Application for a non-material amendment following a grant of planning permission.

Demolition of conservatory and construction of two storey extension

Reference number: AW/303/19/HH

Change of window arrangement on of rear elevation (proposed)

Rear Elevation Proposed (West)
Scale 1:100

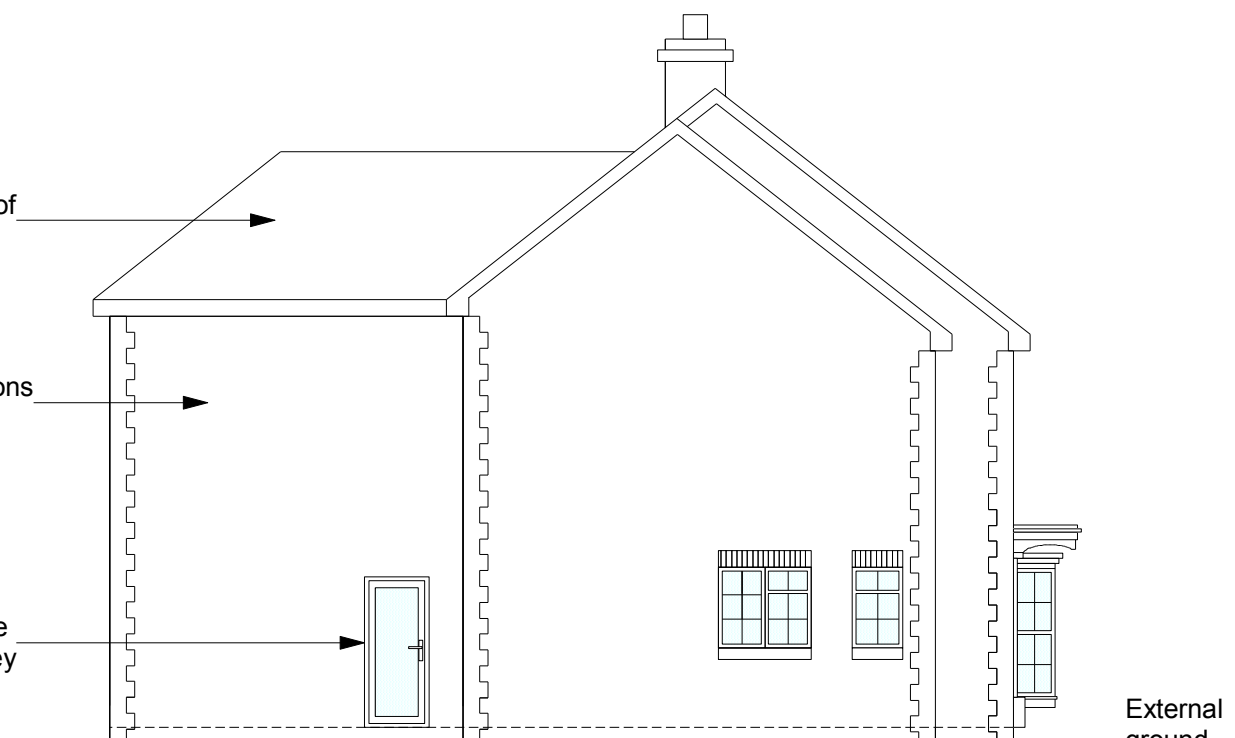
Due to proposed internal room reconfiguration (F,F & E) and to reduce overall size of windows on this elevation.
